Boston Alternative Energy Facility

**Appendix J2 to Natural England's Deadline 5 Submission**

**Natural England's Advice on Outline Landscape Ecological Mitigation Strategy  
(OLEMS) [REP3-008]**

Planning Inspectorate Reference: EN010095

TITLE
**WHARF GENERAL LAYOUT DRAWING
FIGURE 5.2 - SHEET 2 OF 3**

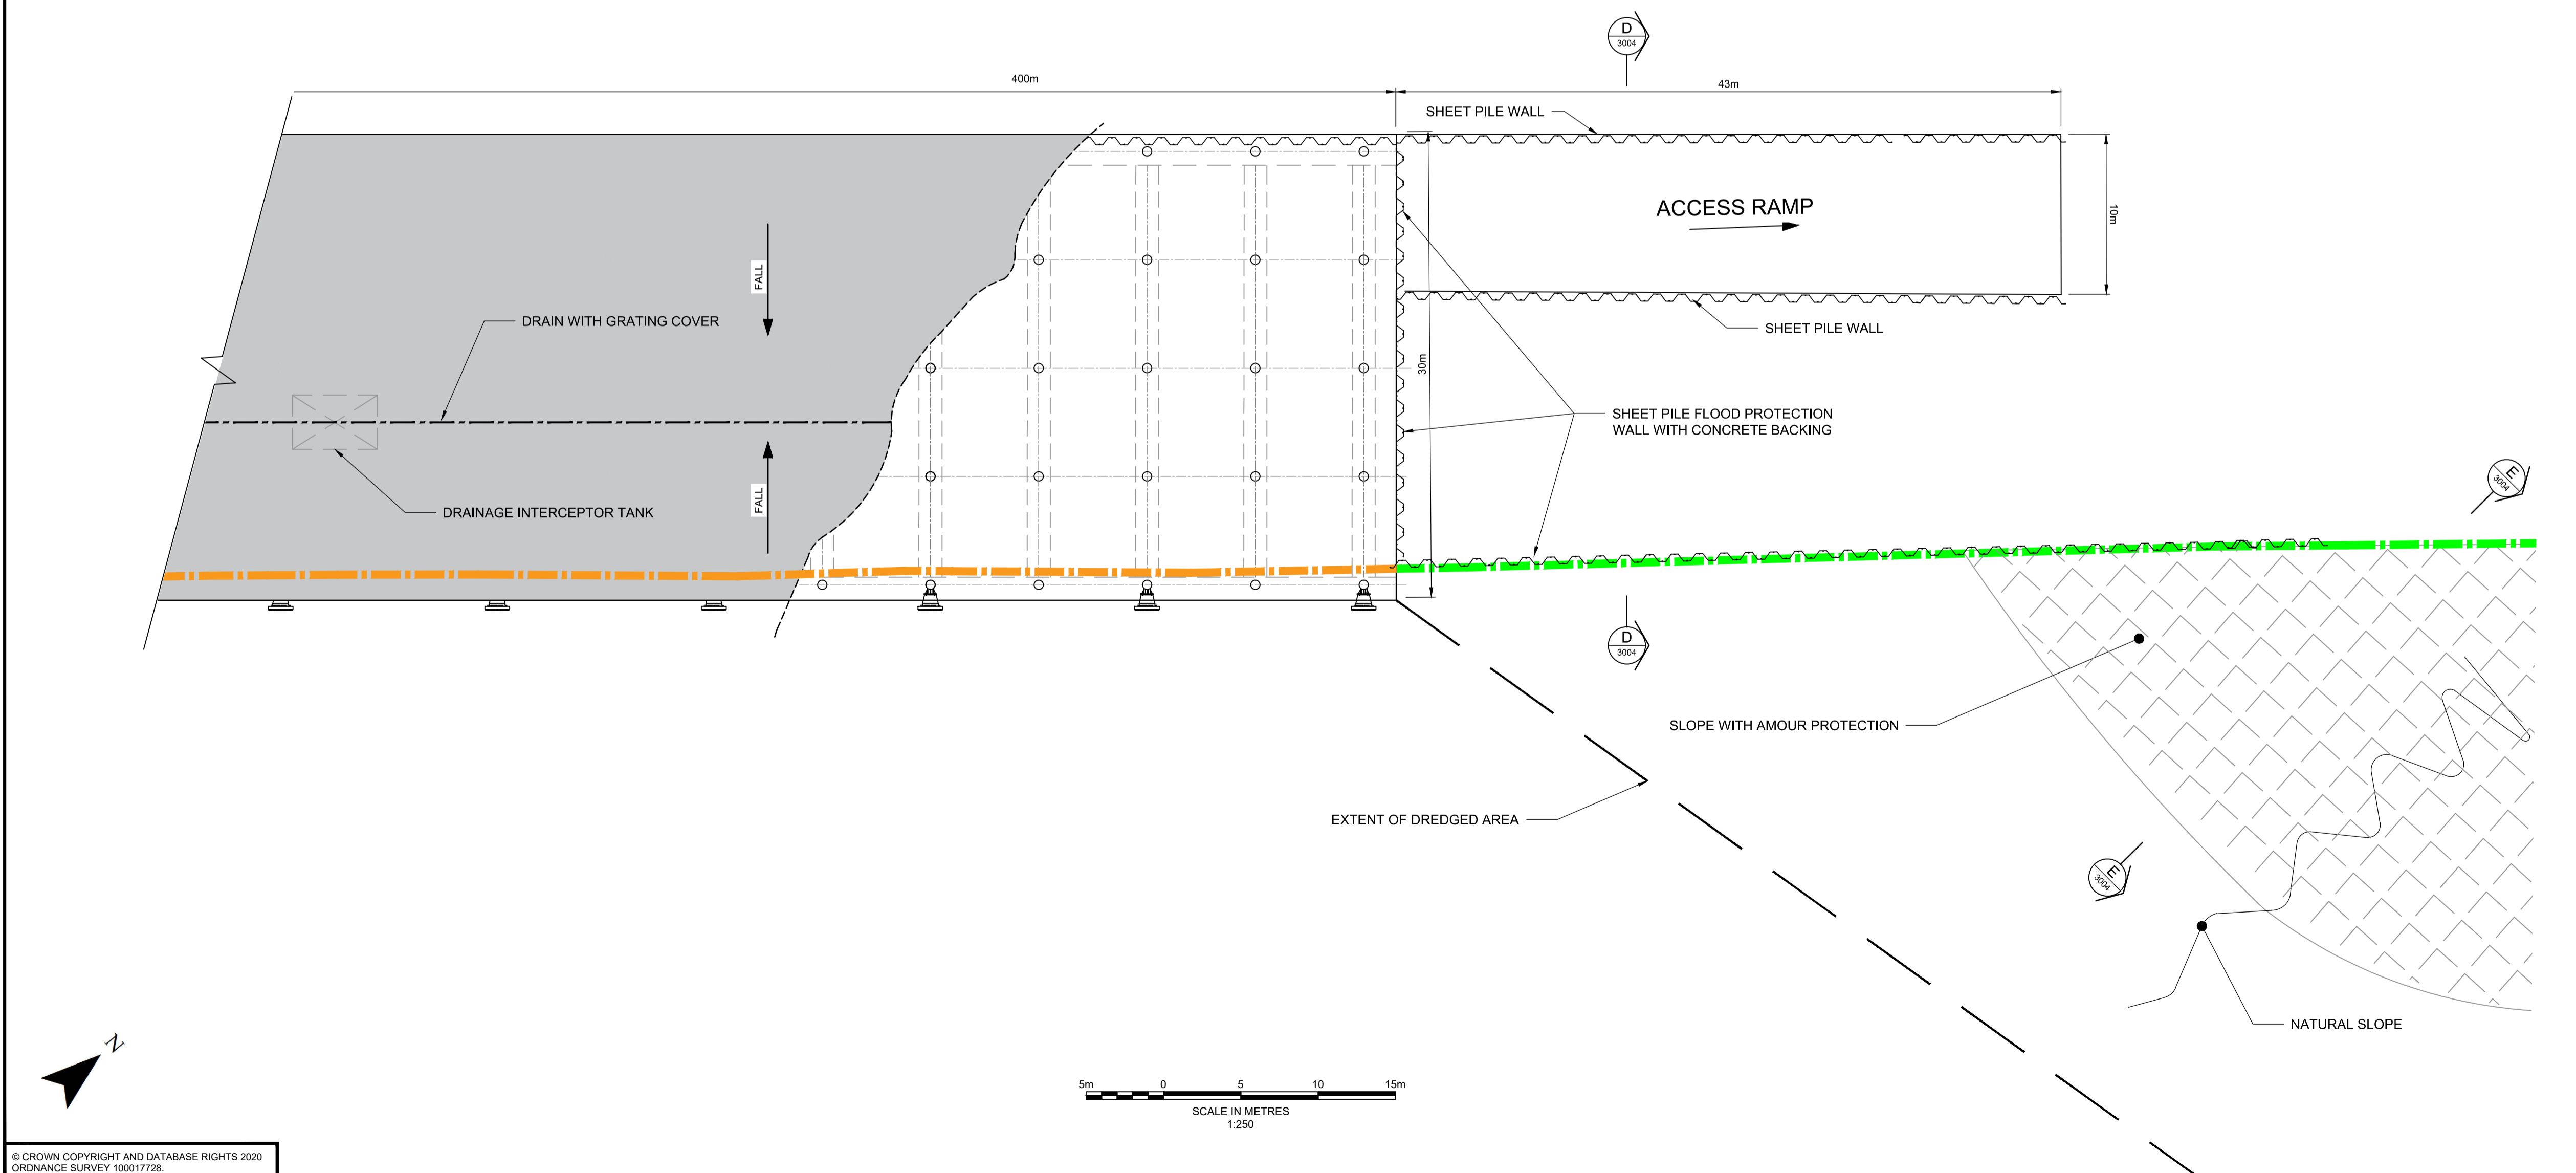
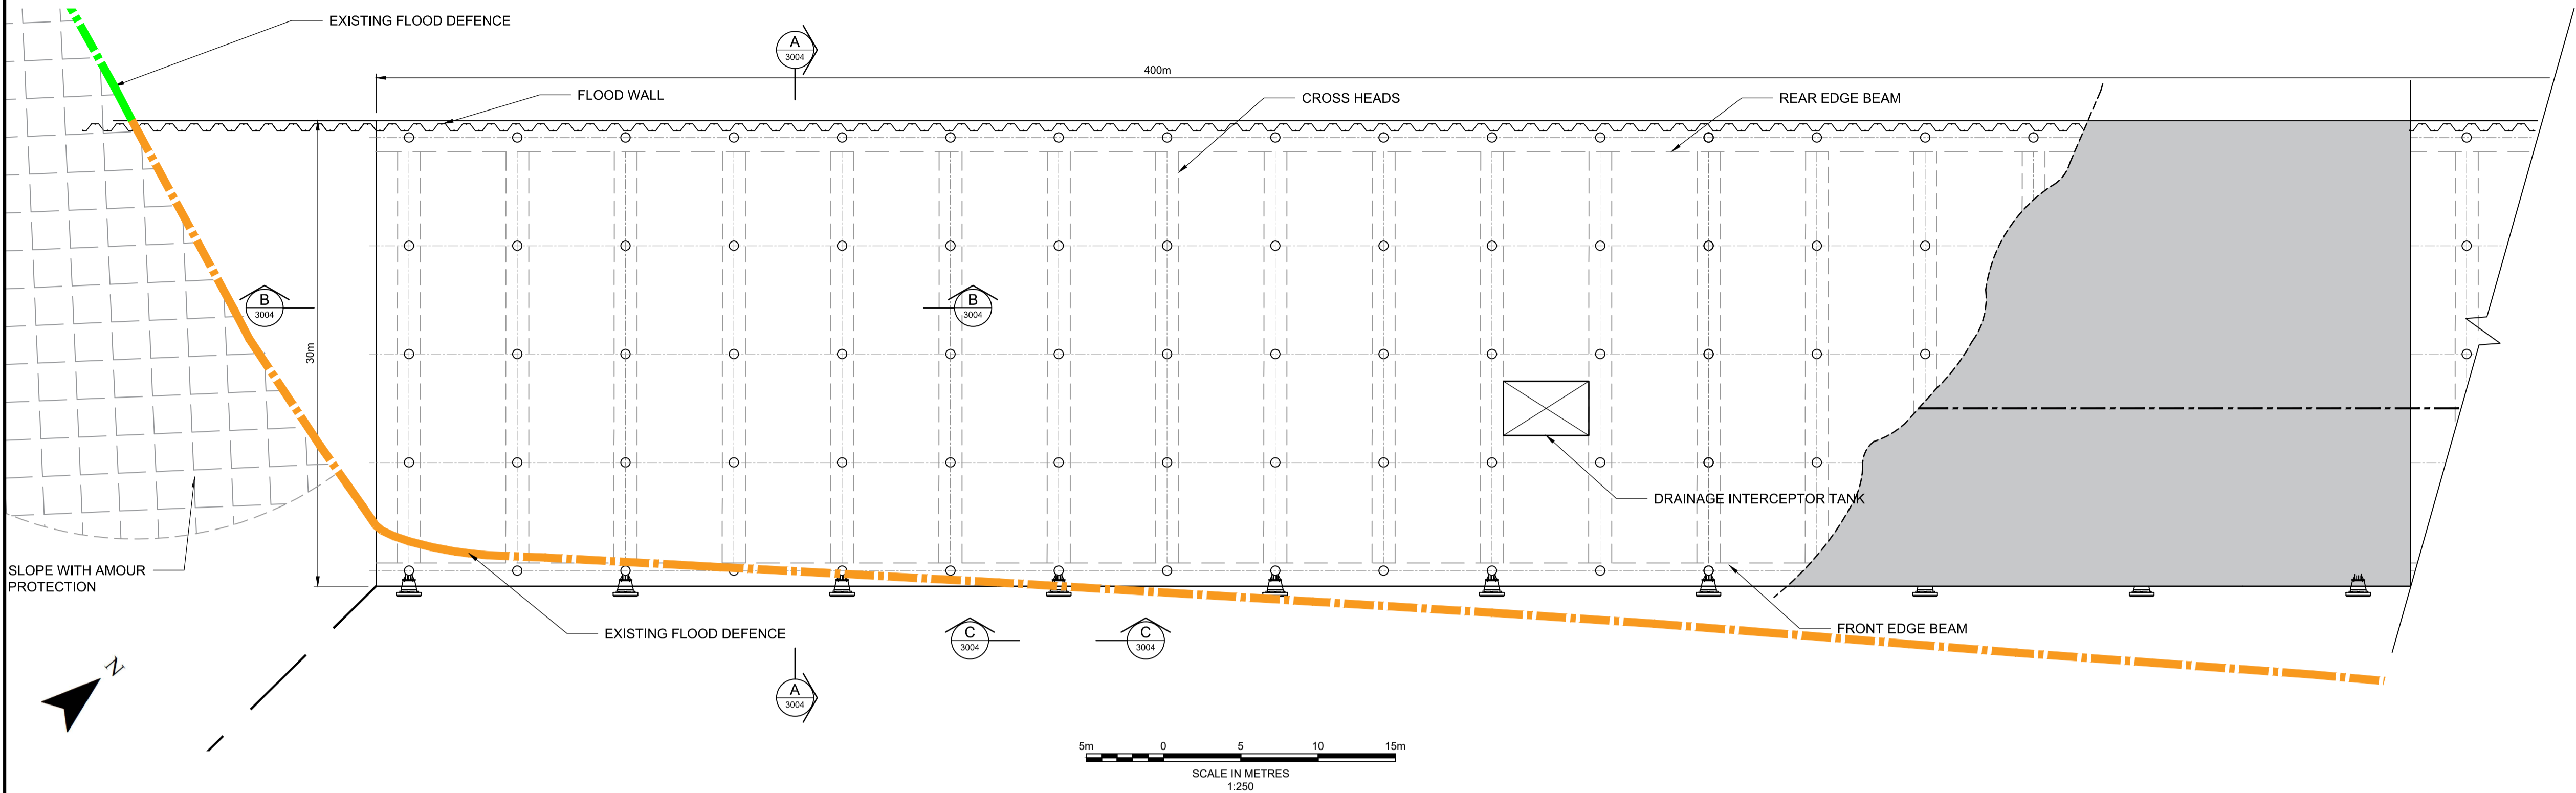
A1.2.1	Natural England advises the created roost habitat will need to be maintained long term to ensure it remains fit for purpose. In addition, we advise that optimal roosts are protected by water which limits risks from terrestrial predators. A useful document covering artificial roost design can be found at: [REDACTED] [REDACTED]	
Plate A1-3	Plate A1-3 Mitigation measures proposed for the Habitat Mitigation Area - NE notes that the plan is to " <i>decrease the gradient of the bank</i> " Natural England requests that more

<p>details on this method / area is provided as we are concerned that this will increase visual disturbance to birds using the saltmarsh from the footpath?</p> <p>We also note proposals to “Flatten/ remove the old bank “are included. As above more details on this have been requested previously – in terms of method used, the volume of material, length of bank (extent) etc. But they are not included. There could be impacts to existing saltmarsh, but if done well there are opportunities to restore/ create more low-middle marsh saltmarsh in the Habitat Mitigation Area.</p> <p>Natural England queries if the removal of this bank influence visual and noise disturbance to birds using the saltmarsh (from the footpath and also from The Haven Channel).</p>	
A1.2.2	<p>The introduction of these mitigation features are not expected to have any adverse impacts in themselves as the works are relatively minor.</p> <p>As noted above, the removal of the old bank and decrease the gradient of the bank could impact the existing saltmarsh.</p>

In relation to the proposed wharf location - while we agree the saltmarsh width is narrow (but not as narrow as stated) with coastal sea defence limiting landward extent; our observations show that there are multiple vegetation zones present/ veg communities present and clearly functioning as saltmarsh

Natural England disagrees as per NE's survey 2021 which identified several NVC communities from upper to low-marsh as present including the typically under-presented community on The Wash SM16; species-diversity at the wharf locations is surprisingly high.
